Project: Bubba's 33 – Albuquerque, NM

Re: Administrative Amendment
Review Comments

Permit #: 2018205.00

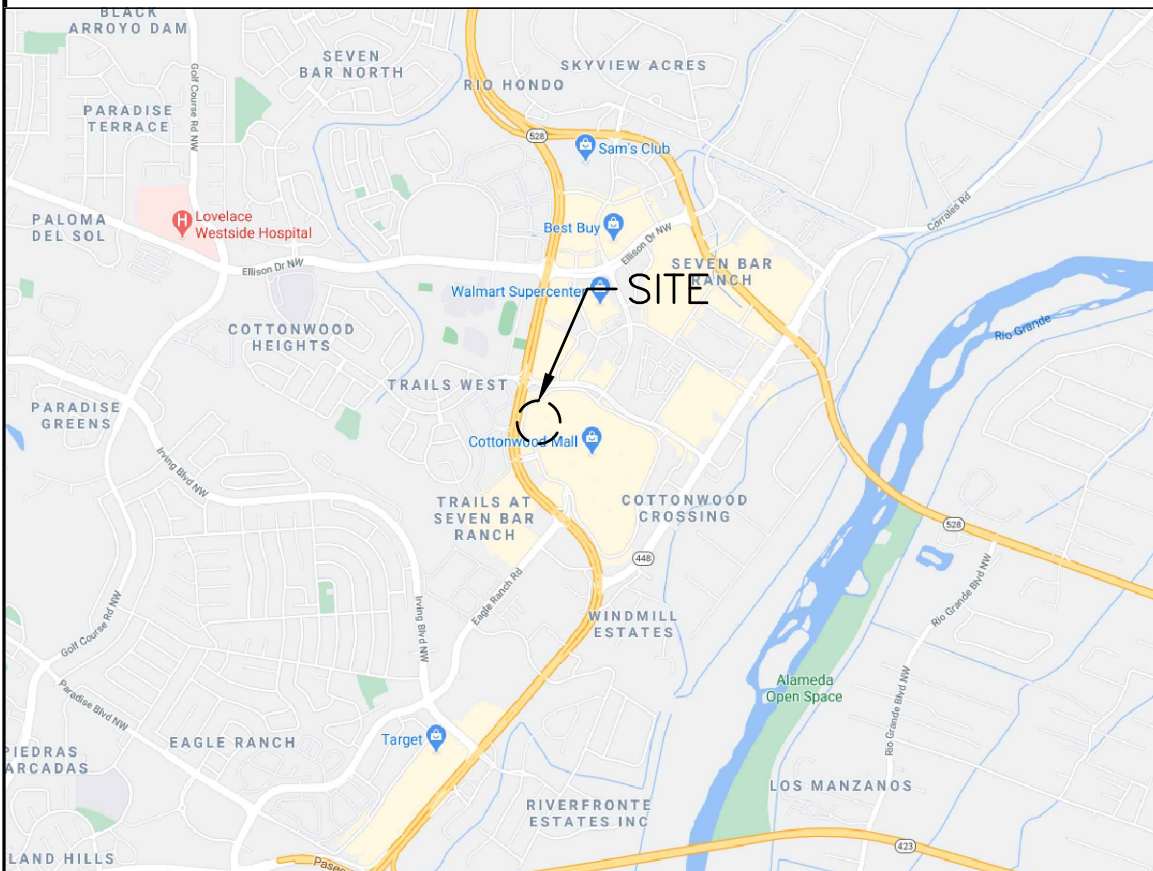
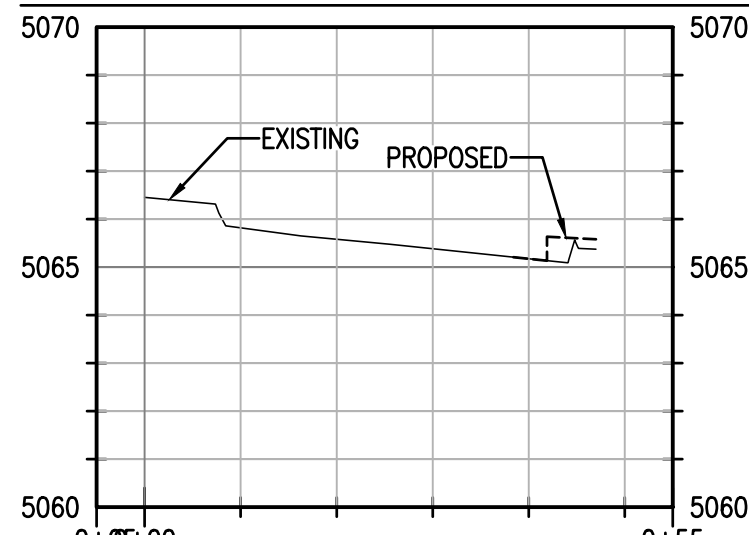
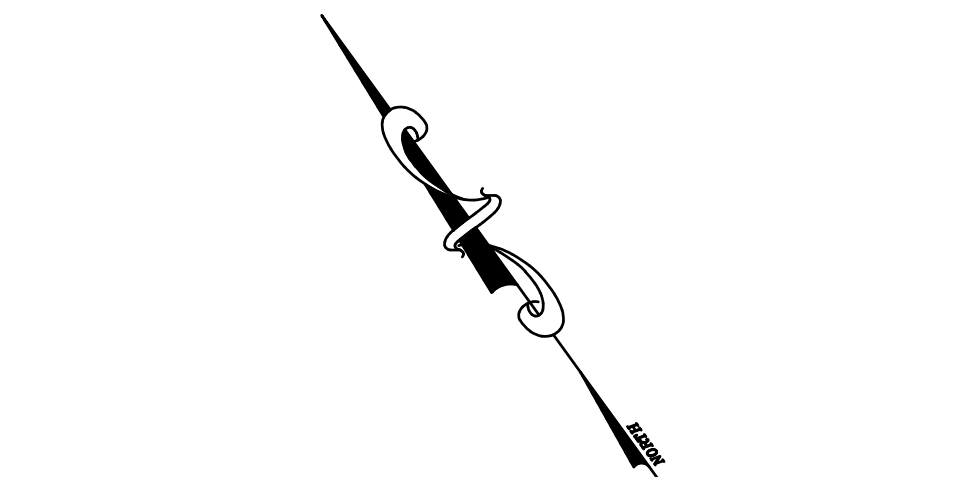
- Our facades are not longer than 100-feet, so we do not need to provide any additional features.
2. Provide additional landscaping detail and calculations. Address areas such as: 5-6-C General Landscaping, 5-6-C-2 Minimum Landscape Area, 5-6-D Required Street Trees, 5-6-F Parking Lot

Landscaping, 5-6-G Equipment/Support areas. *Include clarification for pedestrian connections per IDO section 5-3.

Response: *We received Traffic Review approval, which did not require a pedestrian connection.*
